Application by Green Hill Solar Farm Limited for Green Hill Solar Farm [EN010170]

The Examining Authority's third written questions and requests for information (ExQ3): Issued on 18 February 2026

Responses are due by deadline 6: 24 March 2026

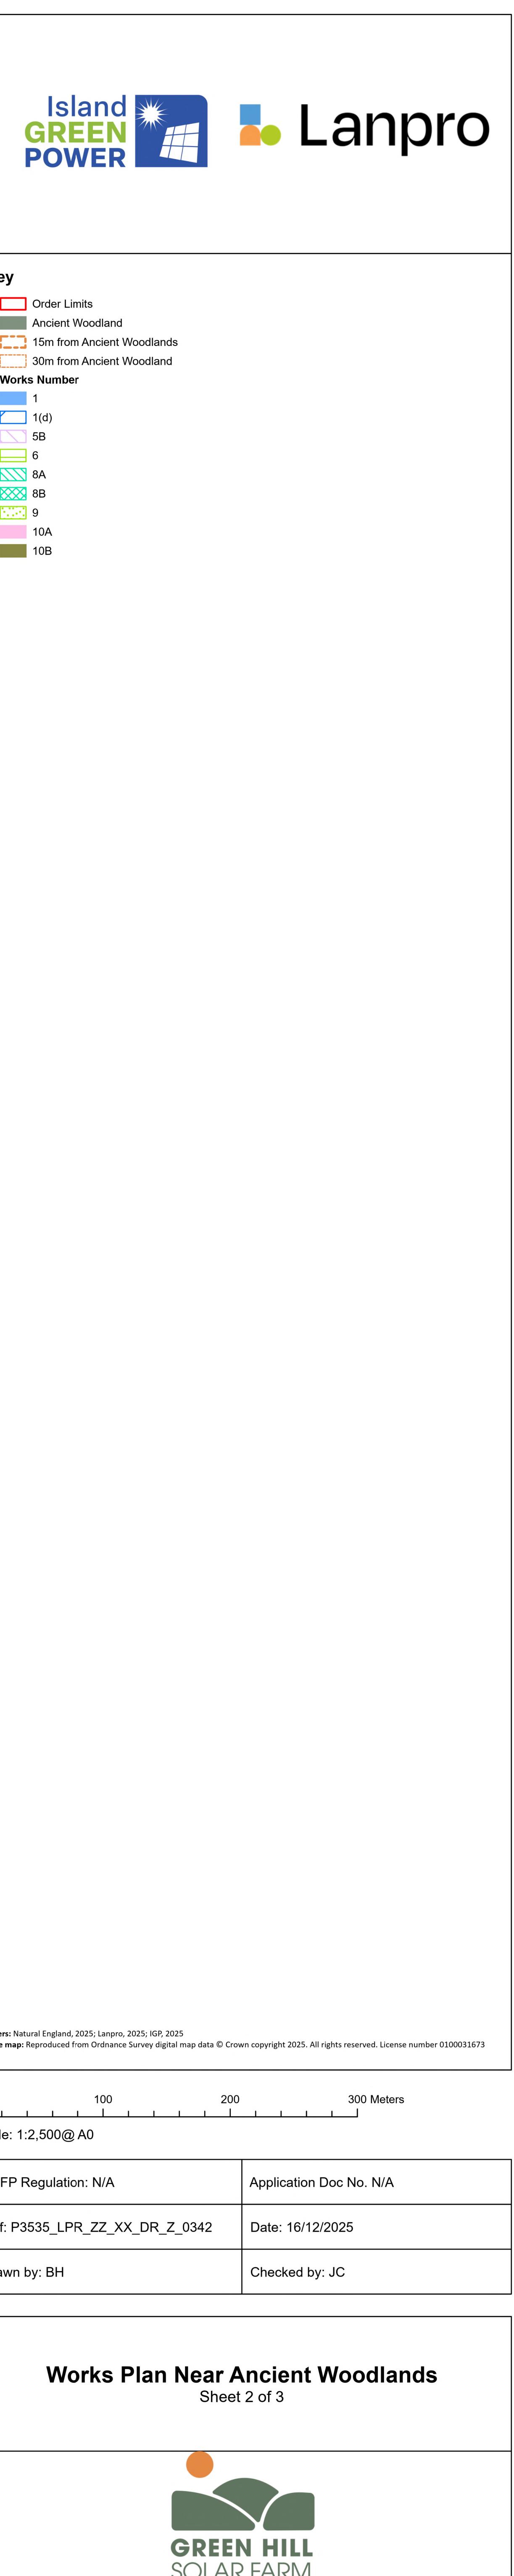
Q3.2.2	The applicant	<p>Signposting Document clarification</p> <p>The Signposting Document for Matters Raised at Issue Specific Hearings [REP4-024] refers to 15 metre and/or 30 metre buffers in respect of Work Nos. 5B/5B(vi)/8B at Sywell Wood, Horn Wood and Barsley Spinney ancient woodland. Please clarify where these buffers are secured, as they are not shown in the Schedule of Protective Ecological Buffers [APP-095] secured (through Requirement 8 of the draft development consent order) at paragraph 3.3.2 of the Outline Ecological Protection and Mitigation Strategy (Revision B) [REP4-010], as confirmed in the response to Q2.7.2 in the Applicant's Responses to ExA Second Written Questions [REP3-074].</p>
Q3.2.3	The applicant	<p>Ancient woodland buffers</p> <p>The NPS EN-1 and the National Planning Policy Framework categorise both veteran trees and ancient woodland as irreplaceable habitats. The Outline Arboricultural Method Statement [APP-171] sets out that the Cable Route Corridor has been widened up to 120m adjacent to identified veteran trees to provide sufficient space to allow for open cut trenching around Veteran Tree Buffer Zones, ensuring impacts to veteran trees are avoided (secured in the Works Plan [REP3-008]). Please explain why the same protection is not proposed for ancient woodland adjacent to the Cable Route Corridor, including whether constraints such as the presence of the Sywell Aerodrome runway adjacent to the Sywell Wood ancient woodland are a contributing factor to this absence.</p>
